**EARTHSCAPE HORTICULTURAL SERVICES**  
Arboricultural, Horticultural and Landscape Consultants  
**ABN 36 082 126 027**

**Kellyville Park – 6-8 Memorial Avenue, Kellyville**  
**Proposed Centre of Excellence and Community Facilities - SSDA**  
**Addendum [1] to Arboricultural Impact Assessment Report**

EXISTING / DEMOLITION

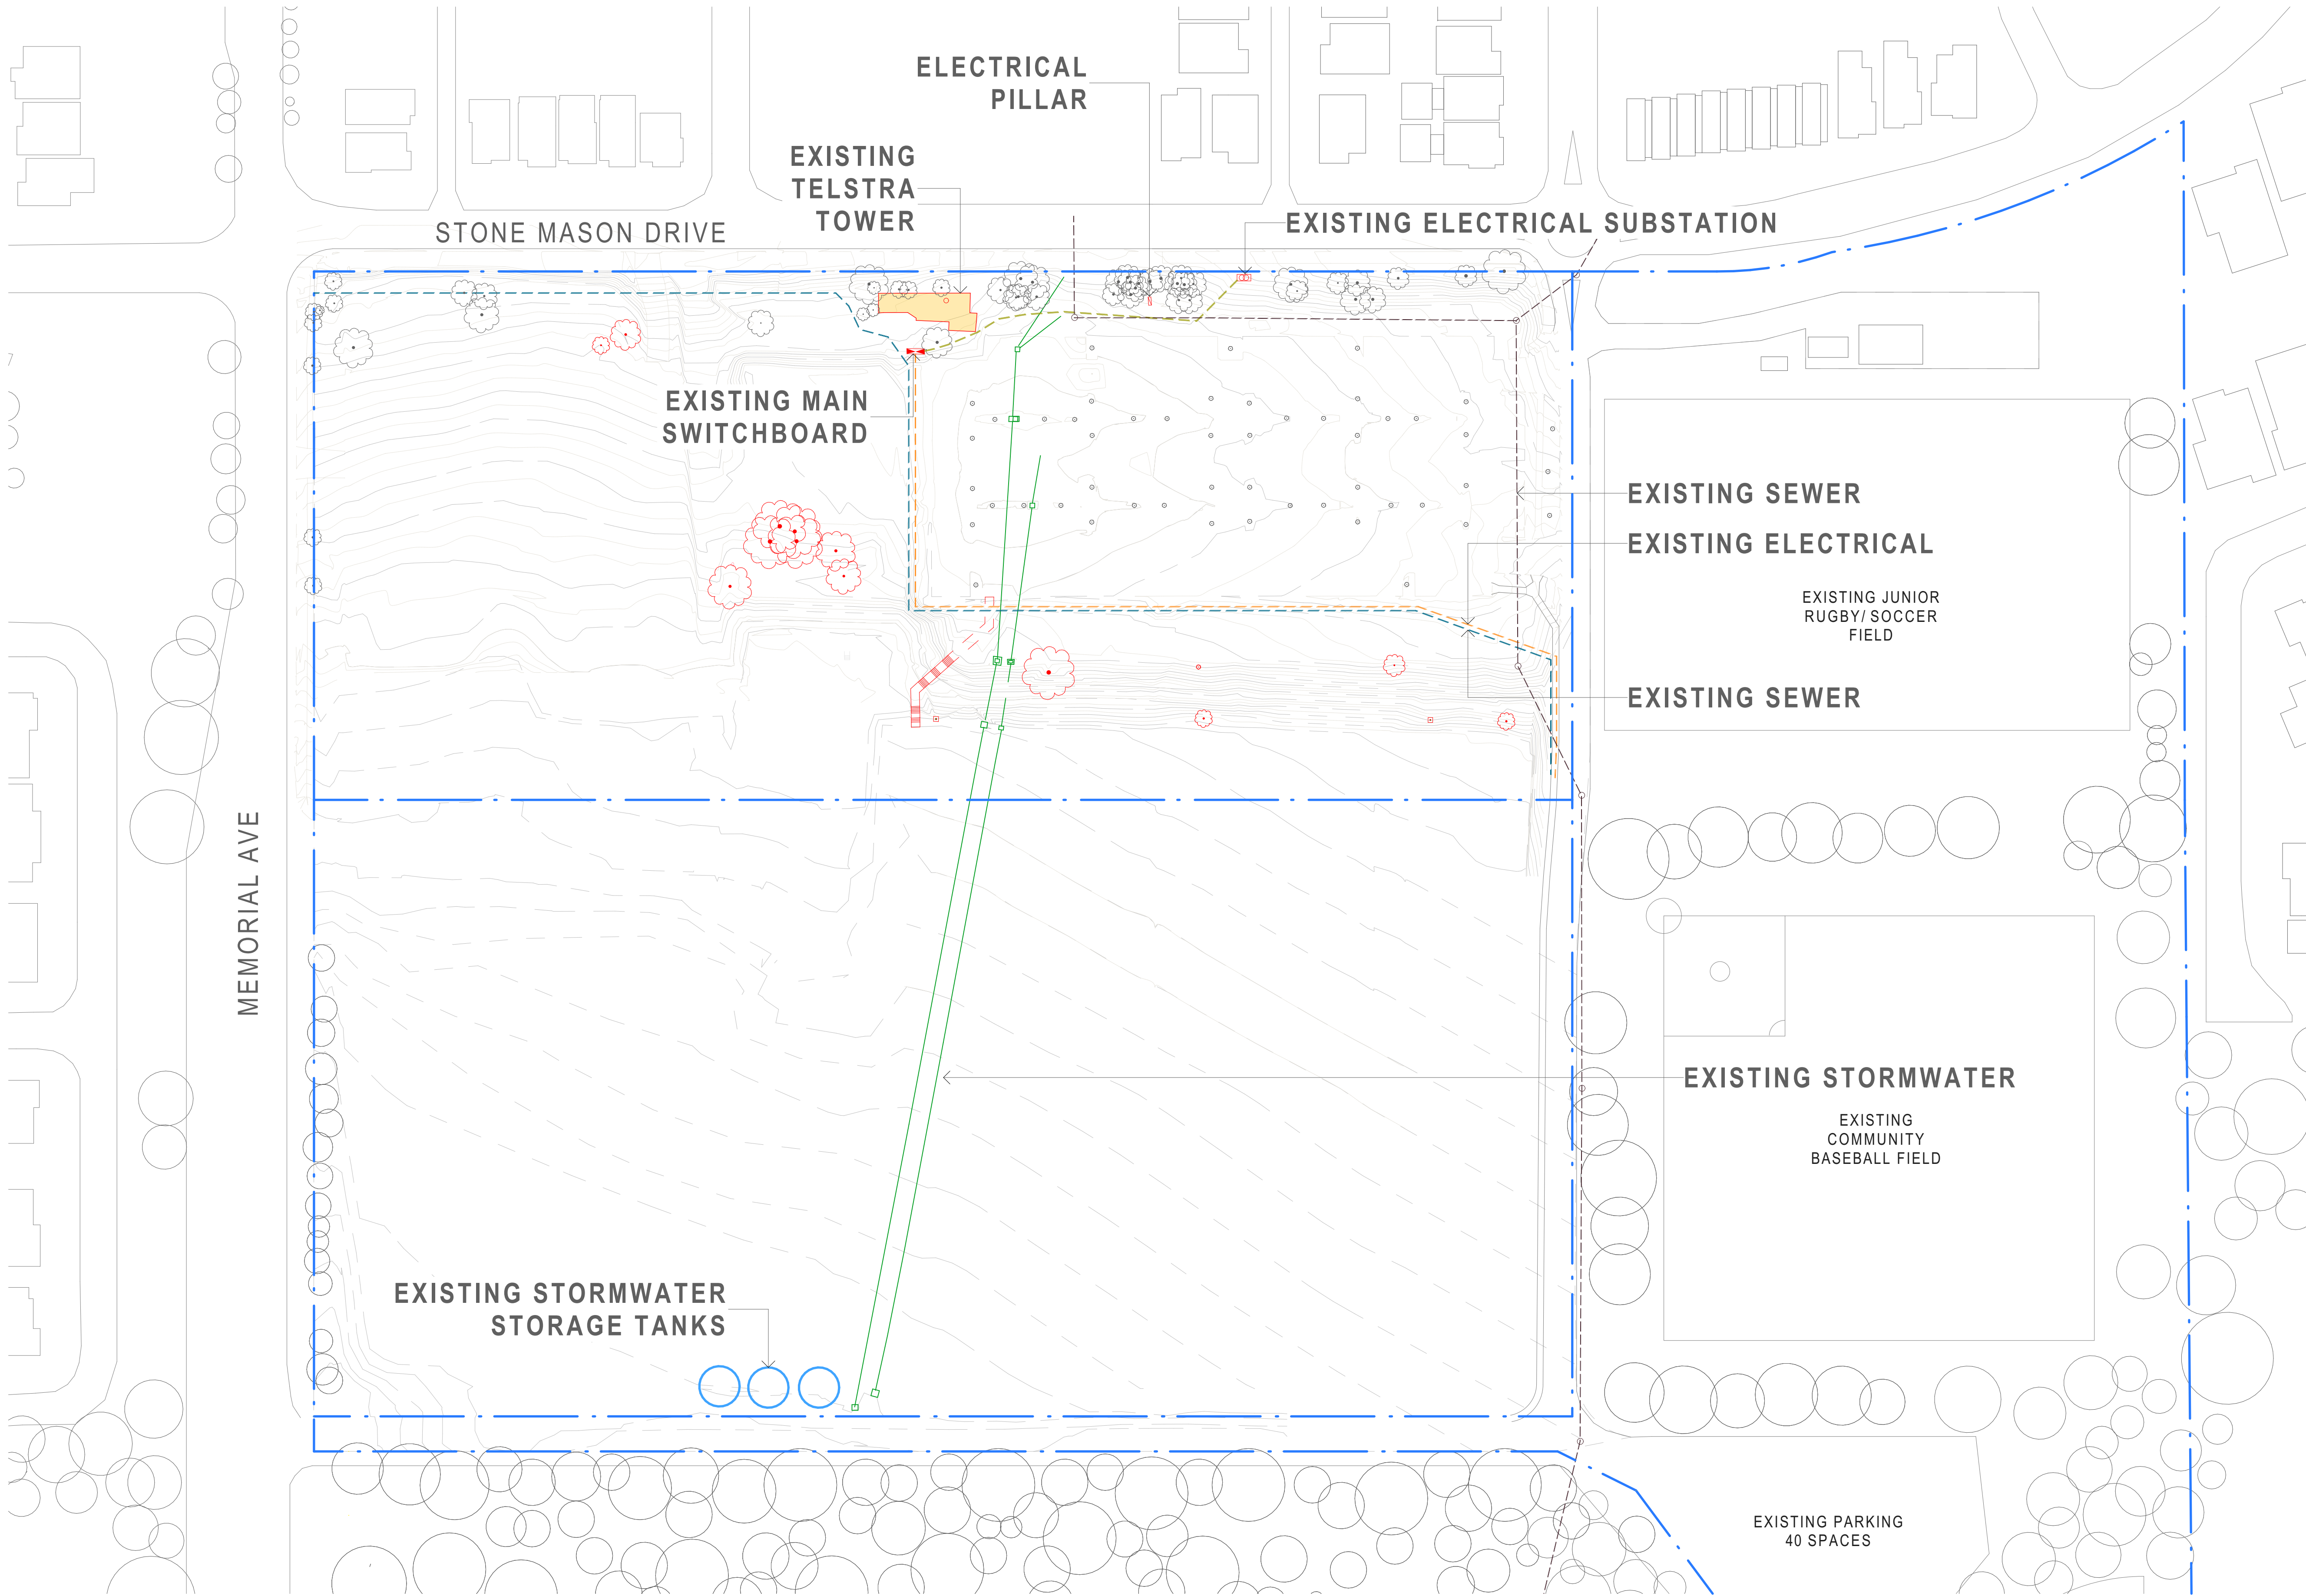
It is understood that the NSW Department of Planning and Environment (DPE) have raised concern about the proposed removal of T17, a *Eucalyptus scoparia* (Willow Gum) to accommodate the proposed development. Item 1.3 of the DPEs preliminary assessment of the SSDA states that “*Tree number T17 (Willow Gum) is a significant tree and options should be considered to preserve and incorporate the tree into the design of the development.*” The following comments are made in response.

The subject tree stands more or less centrally within the site and is proposed to be removed to accommodate the new grandstand (as shown in **Appendix 6** of the abovementioned report). There are no feasible options that can be recommended that would permit this tree to be retained unless substantial redesign of the site were to occur. The Tree Protection Zone (TPZ) calculated in accordance with AS4970:2009 is **12.8 metres radius** (refer to **Section 7** and **Appendix 4** of the abovementioned report), which is a significant constraint to the development of the site given the location of the tree.

The subject tree is a solitary planted specimen of approximately 15 metres in height, 16 metres crown spread and 1 metre trunk diameter. It is agreed that the tree has substantial dimensions and makes a fair contribution to the amenity of the site. However, as noted in **Sections 5.2** and **5.3** of the abovementioned report, the subject tree has no special ecological or heritage significance in the context of this site. The tree was assessed to be in fair health and condition, containing a number of wounds and broken branch stubs (some of up to 200mm in diameter) throughout the crown due to previous storm damage and a moderate wound and cavity on the lower trunk with decay evident. The tree was therefore assessed to have a relatively short remaining Safe Useful Life Expectancy (SULE) of between 5 and 15 years (refer to **Appendix 3** and **Section 4** of the abovementioned report detailing the assessment methodology). Based on the landscape significance and SULE of the tree, it was assigned a moderate retention value (refer to **Section 6** of the abovementioned report, detailing the assessment methodology).

Whilst the preservation of Moderate Retention Value trees is desirable, they should not be considered a significant constraint to site development. Replacement planting with new trees of appropriate species is generally considered an acceptable alternative where the retention of such trees is simply not feasible (refer to **Table 2** in **Section 6** of the abovementioned report). As such, given that there were no acceptable alternatives to retaining the tree in the context of the proposed development, removal and replacement with new trees is considered warranted in this instance.
